Application No: FG/46/21/PL
Site Address: Land between 11a The Grove and 30 Brook Lane Ferring
Description of works: Development of 1 no. 2 bed house set over 2 floors, with first floor being partially contained within roof, along with associated parking & amenity spaces. This site is within CIL Zone 4 and is CIL liable as new dwelling.

Thank you for your internet representation made on 30th April 2021 which has been recorded as an objection with the comments as follows:

Drawing Title 028_02 Proposed Ground Floor Plan Land between 11A The Grove and 30 Brook Lane, Ferring					
Completion date 17/03/2021					
Drawn by Guy Rochez ARB					
Scale: 1:100@A3					
Print Size: A3					
Notes:

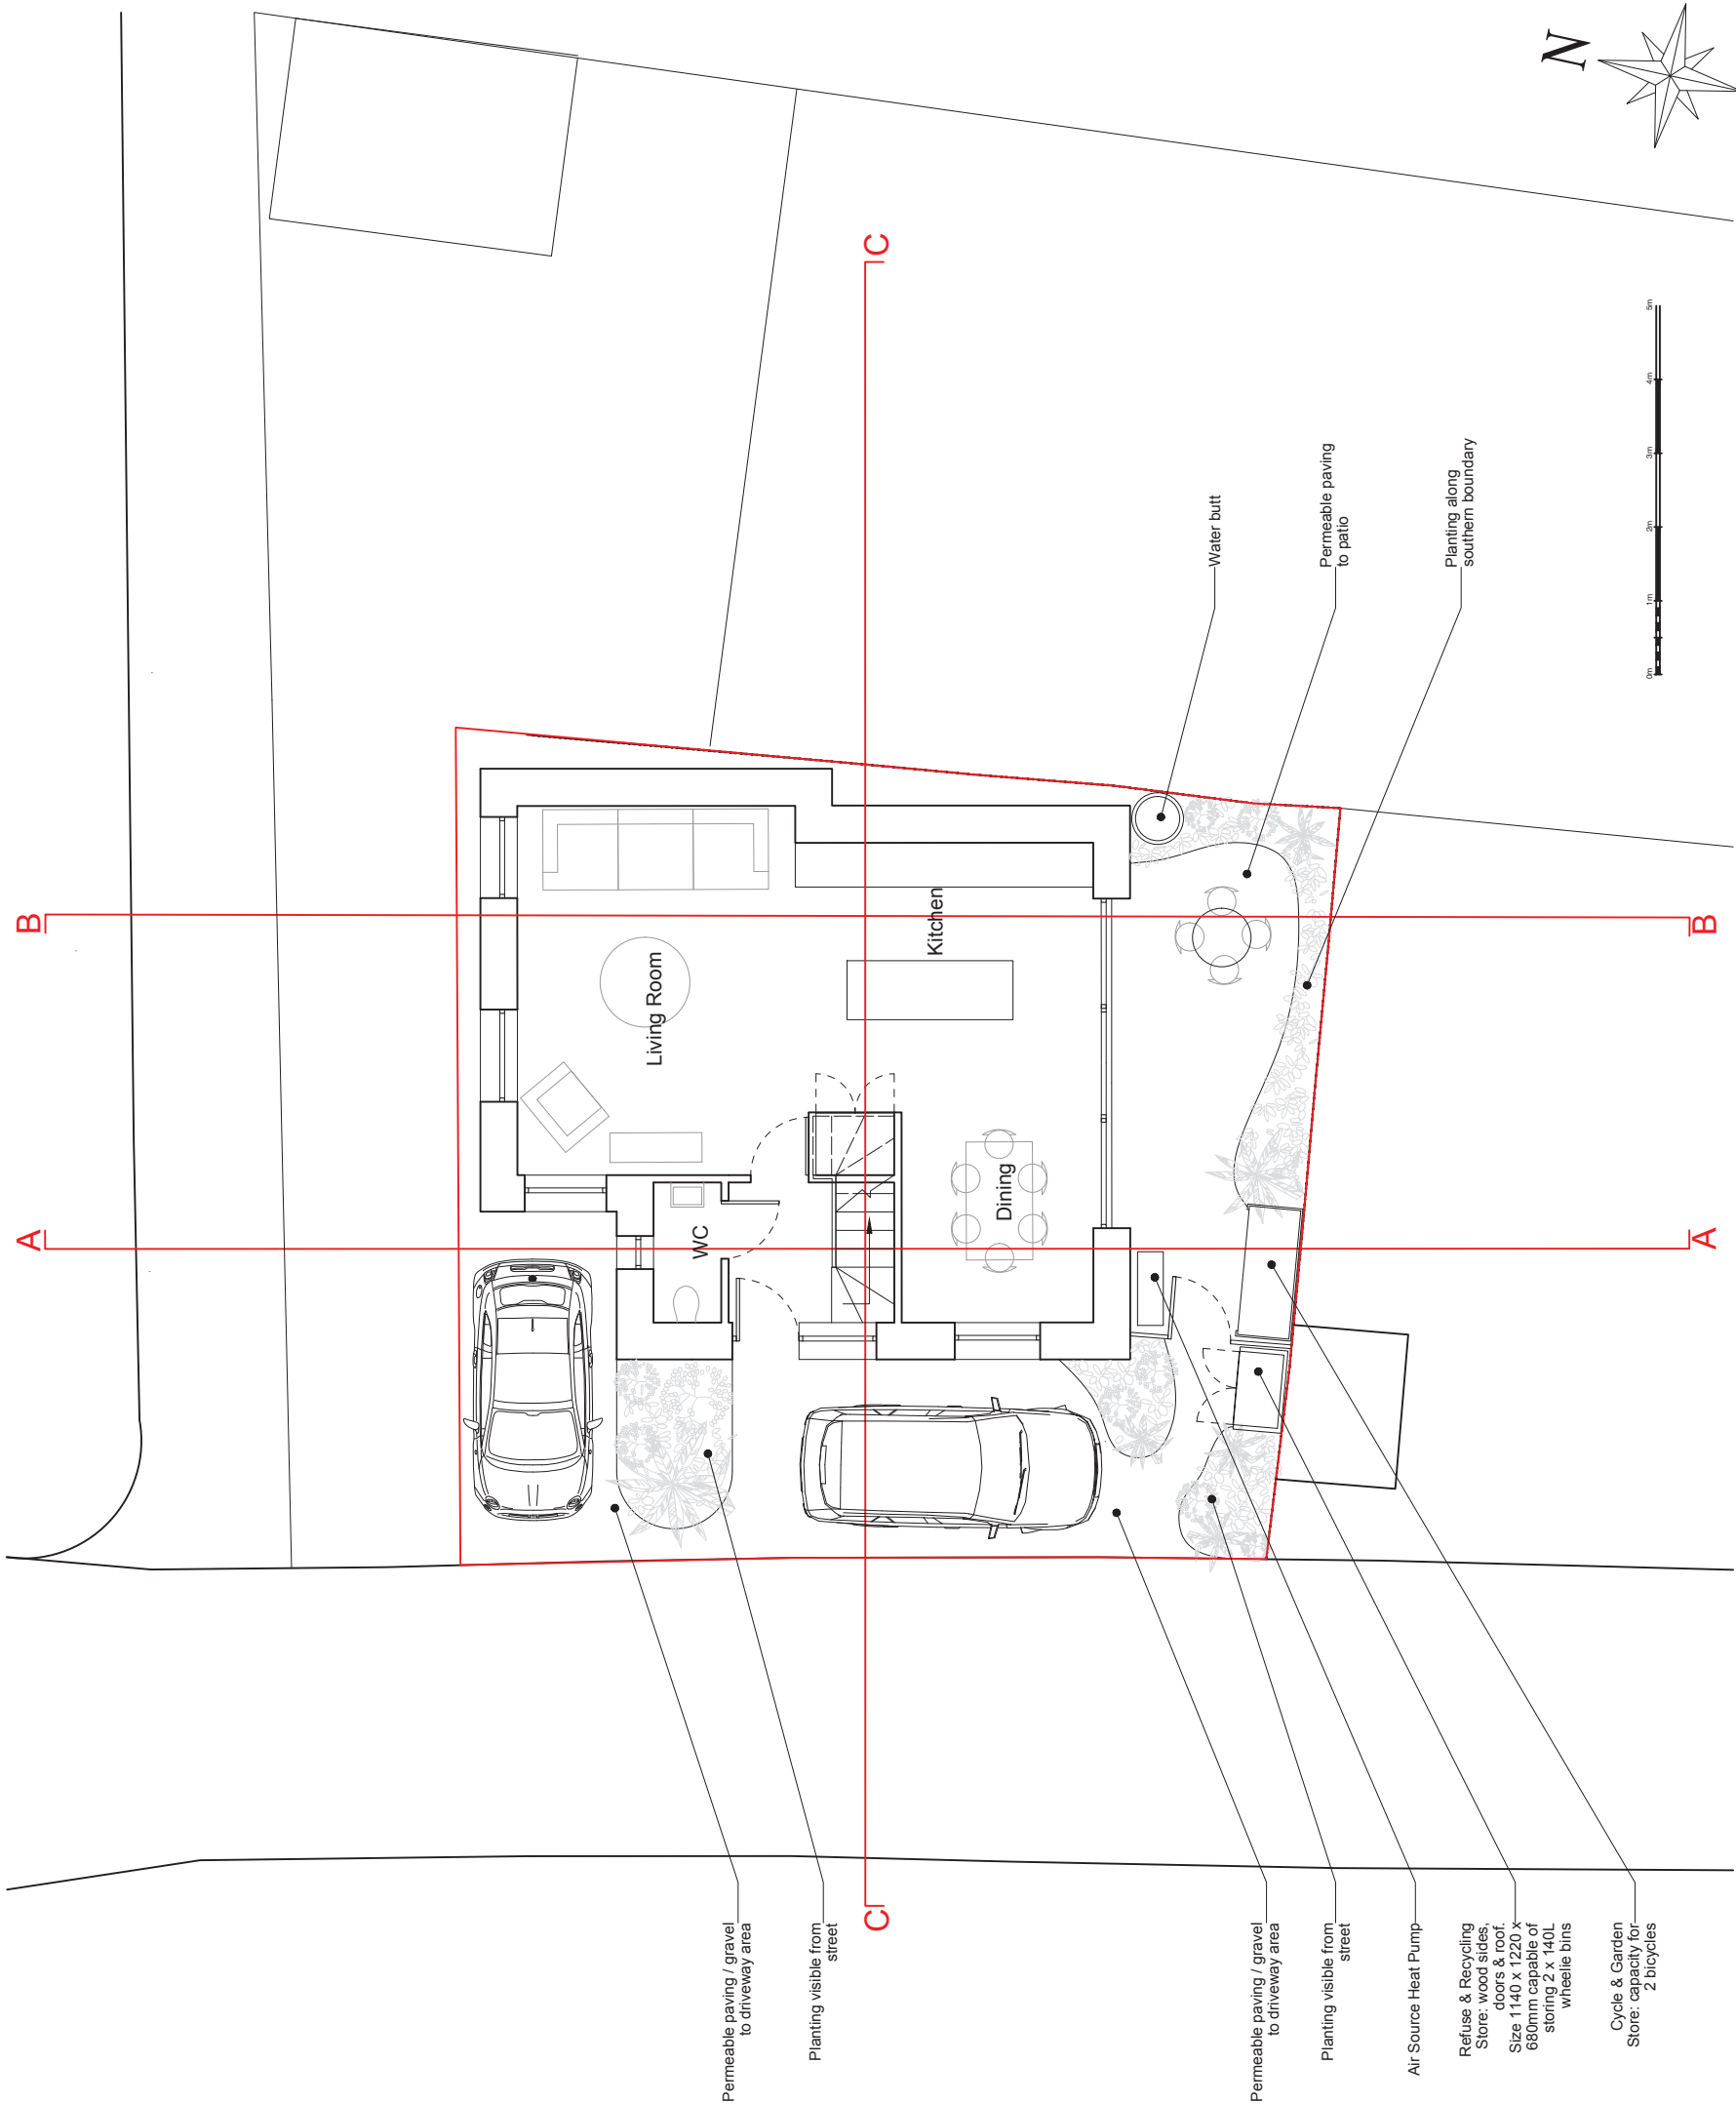
- parking is already tight in The Grove and I cannot see that the parking space identified on the plans is the correct measurement and fits with planning regs. If this overlaps into either the road area or the access road to the other property in Brook Lane it will creat serious congestion and safety issues.

Drawing Title
028_03 Proposed First Floor
Plan
Land between 11A The Grove
and 30 Brook Lane, Ferring

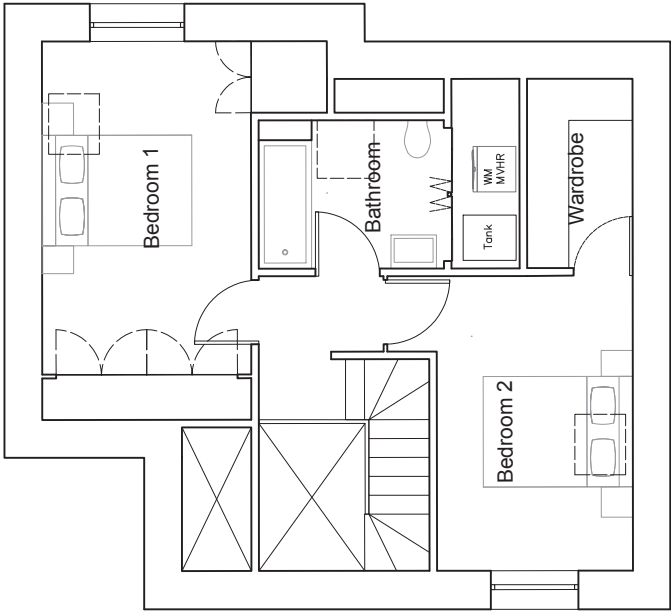
- unacceptably close / overshadowing a neighbouring property by the back wall of the proposed property against the boundary with 24 Brook Lane. This would unacceptably affect the use of the owners back garden and would allow them to be overlooked even with a velux window only in room 1. Additionally, this proposed property will mean that the garden will also be shaded in the afternoon although the builder states this will not be the case - this is incorrect.
